Appeal Decision

Appeal Ref: APP/R4408/W/25/3362015

Land adjacent to Three T's Industrial Estate, Platts Common Industrial Estate, Platts Common, Barnsley S74 9DG

- The appeal is made under section 78 of the Town and Country Planning Act 1990 (as amended) against a refusal to grant planning permission.
 - The appeal is made by Wayne Hadfield, Hadfield Developments, against the decision of Barnsley Metropolitan Borough Council.
 - The application Ref is 2024/0305.
 - The development proposed was originally described as hand car wash.
-

Drawing No. MWH002 -001
 Rev No. A

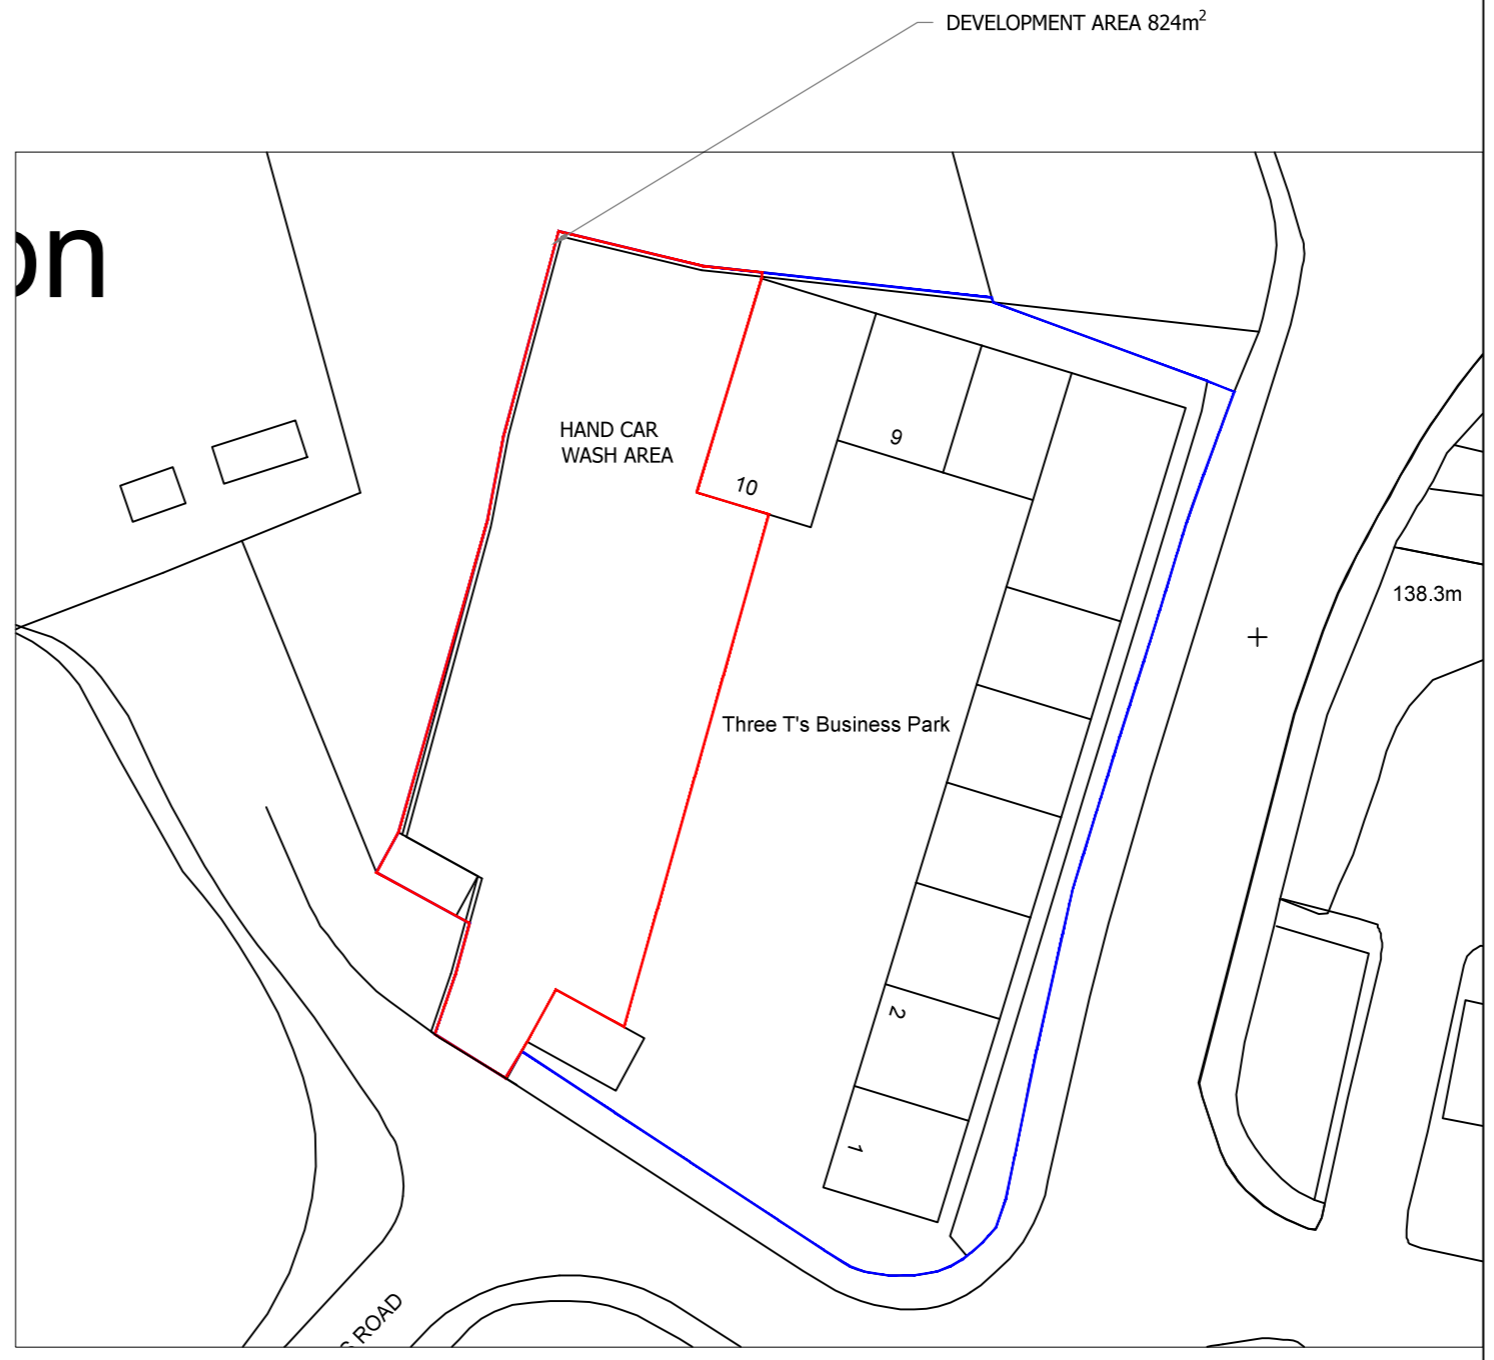
10. The drawings show that the proposed staff and visitor parking encroaches into the parking area of the business park. At the time of my site visit, this area was almost full of parked vehicles and a skip. I acknowledge my site visit was only a snapshot in time and there could be different levels of traffic, customers and parking at other times. Nonetheless, the proposal would affect parking within the business park. This is because the drawings show amended parking for the units and based on the evidence presented, as well as my site visit observations, it is unlikely that there would be adequate space for vehicles to manoeuvre to park or deliver to the units.

15. The plans show the location of an acoustic screen as well as the jet wash and drying areas. At the time of my site visit, noise was being generated by a unit within the business park (CLM signs). However, it is not clear whether this is frequently the case.
